BCA & DDA ASSESSMENT REPORT

**DOOLEYS LIDCOMBE CATHOLIC CLUB
JOHN STREET, LIDCOMBE NSW**

Revision 3

24 June 2016

1 ELEV_SOUTH
1 : 100

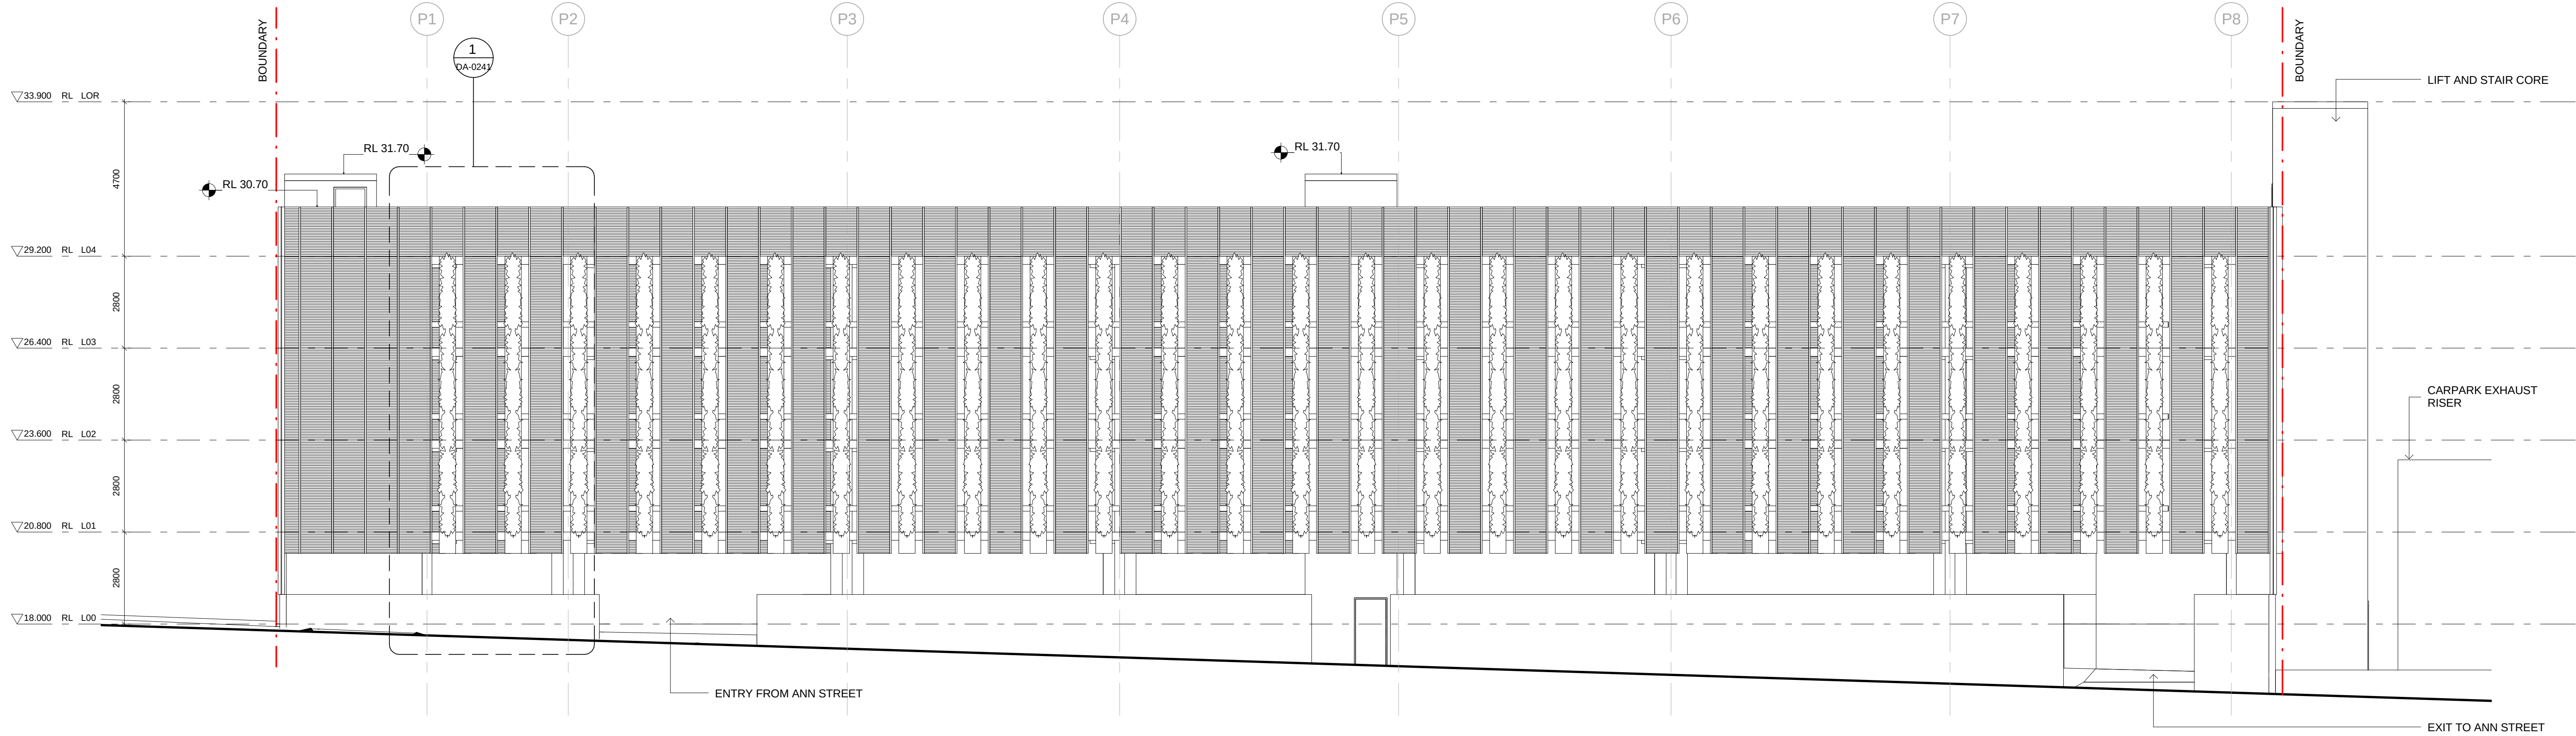
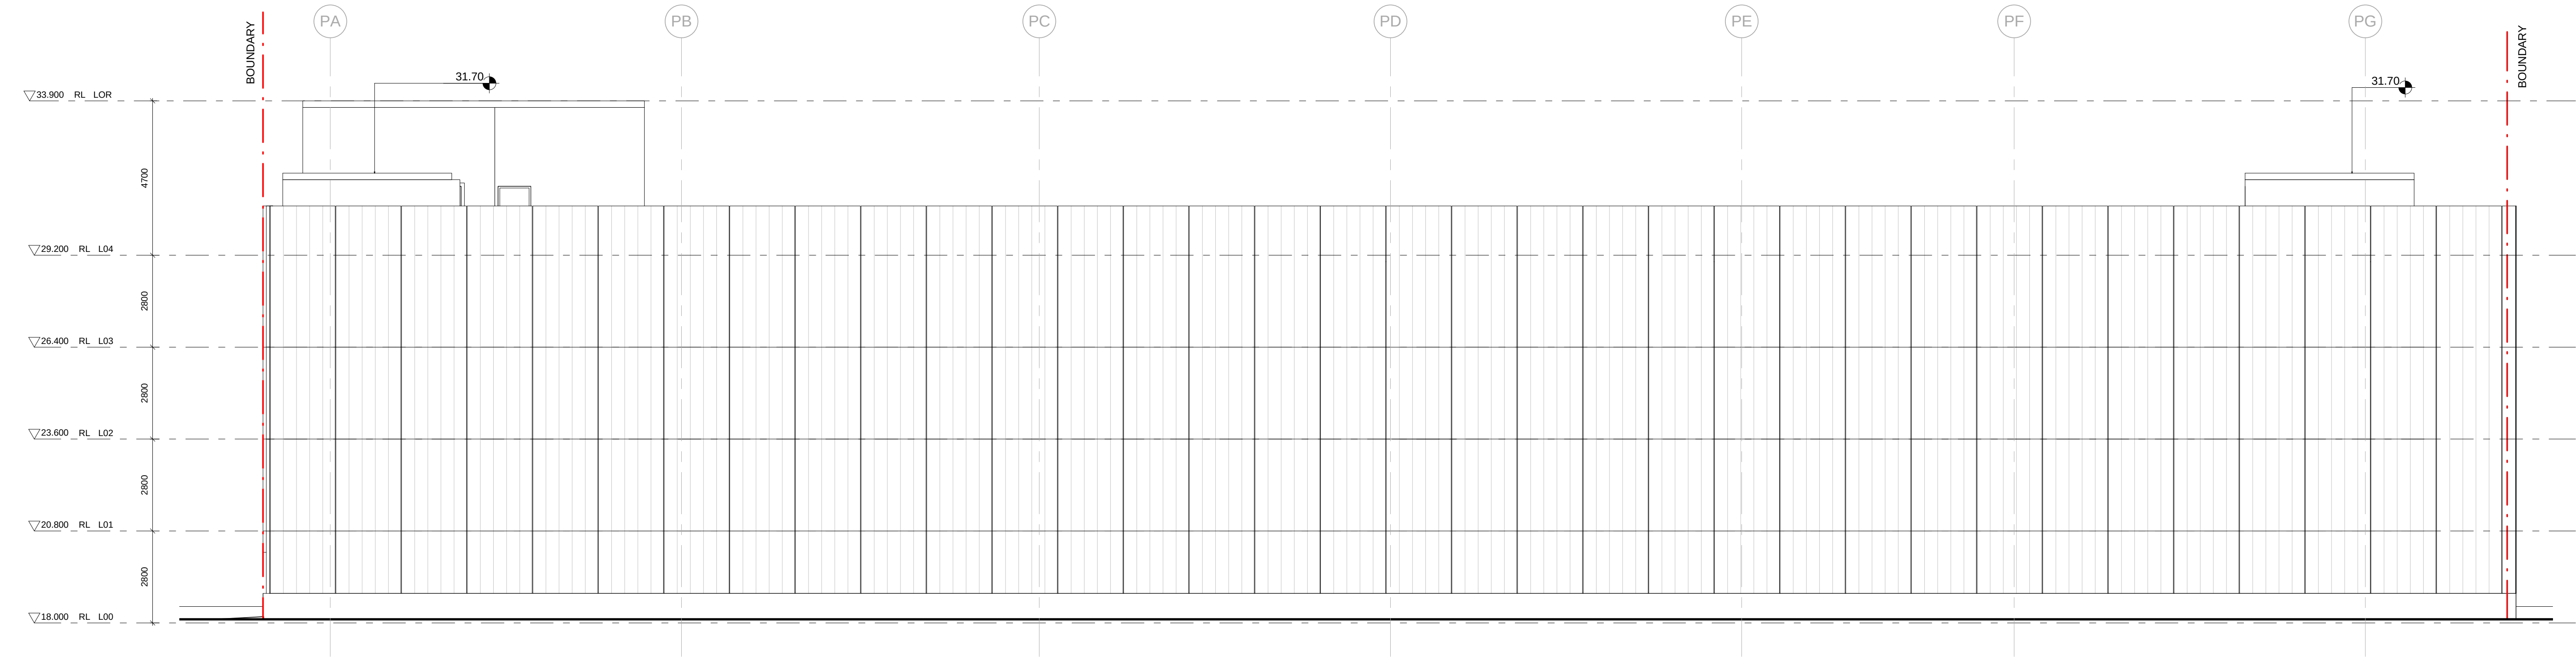
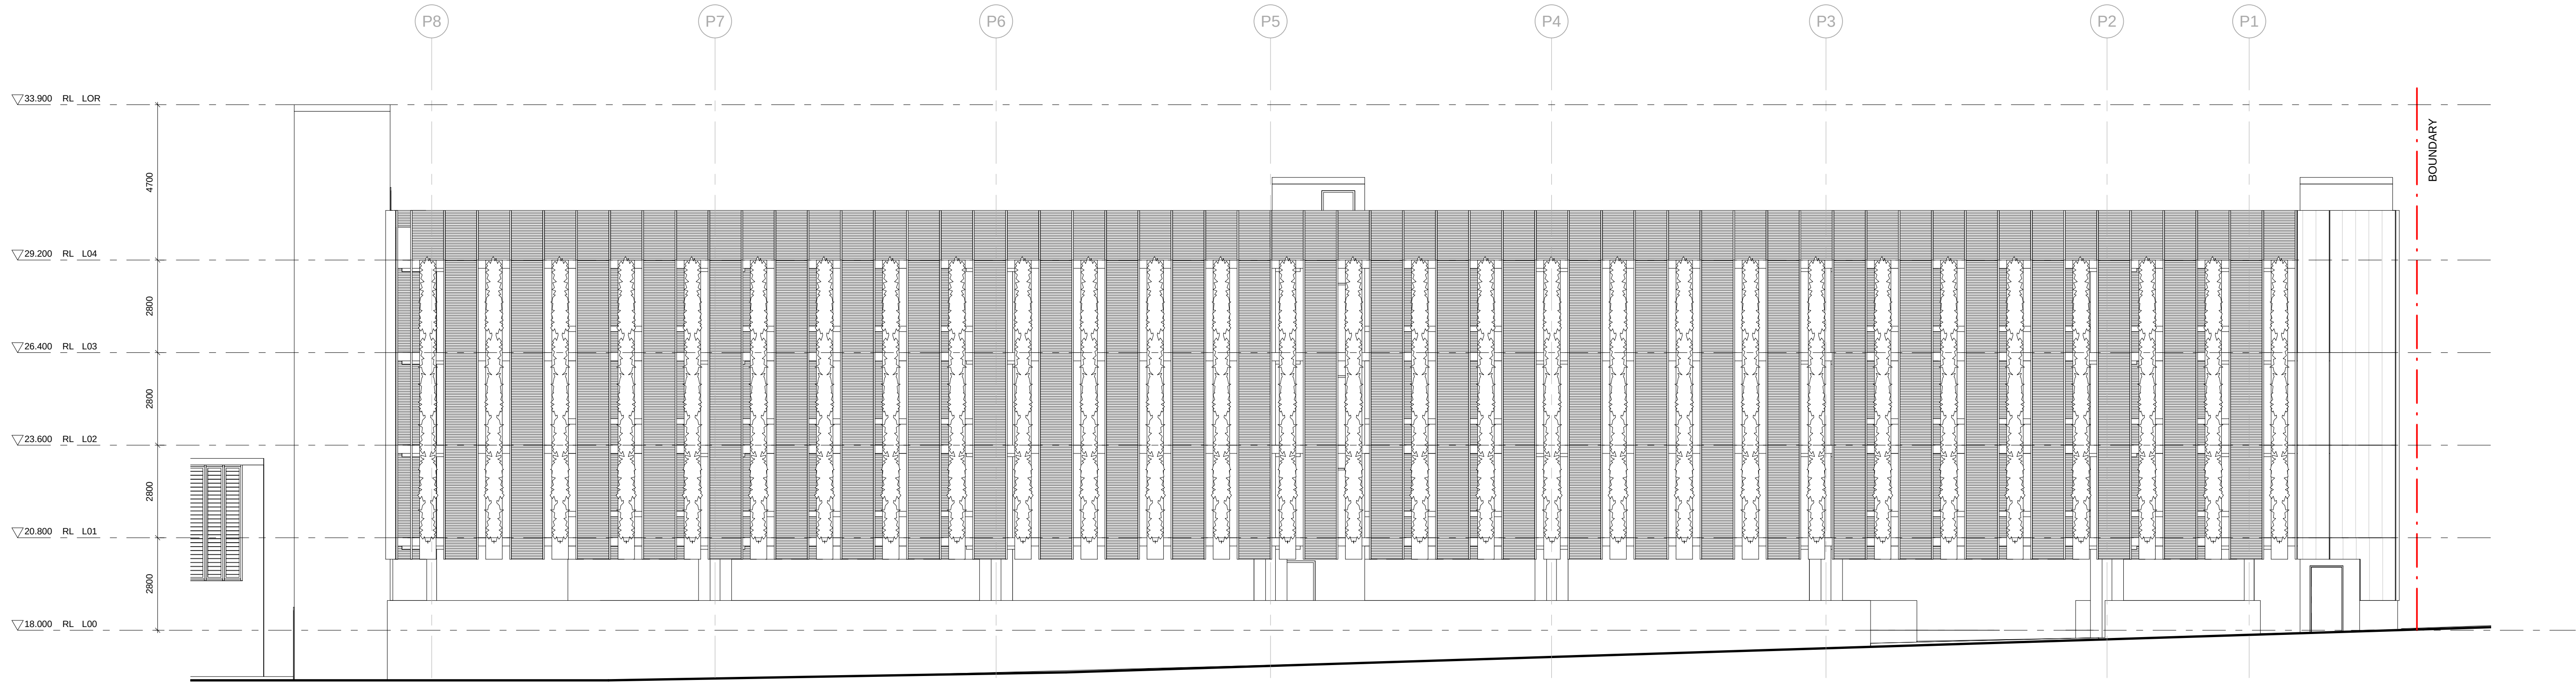
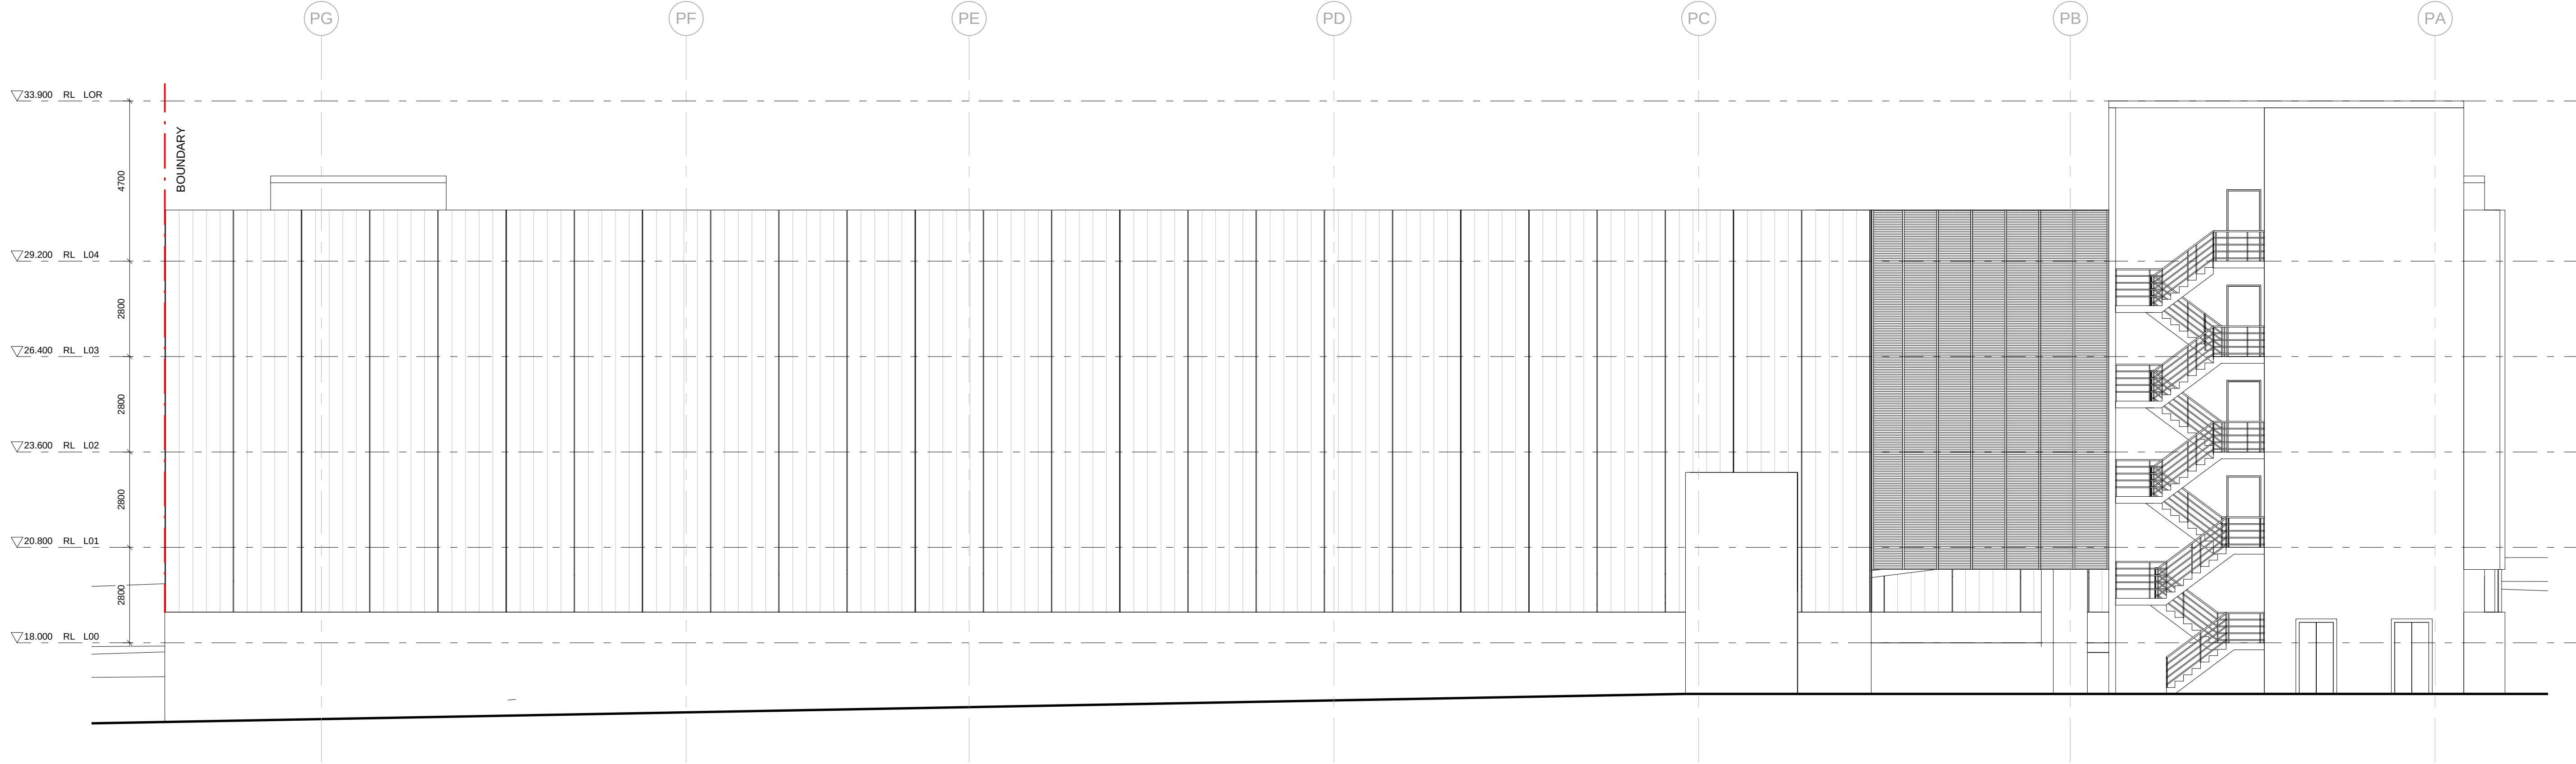
Note 2: The stand-alone carpark building is an open deck carpark by definition given the proposed cross ventilation provided via the northern and southern facades. In this regard the Architect will be required to confirm that a minimum of 50% openings are evenly distributed across these facades to ensure the open deck carpark concessions (detailed below) can be implemented into the design.

3.	Spec. C1.1 & C3.2	The allotment boundary returns along the Broad Street frontage on the SE corner of the carpark building and this portion of the southern façade of the carpark is proposed to be open – an alternative solution will be required to address both FRL and protection of openings in this portion of the southern façade.
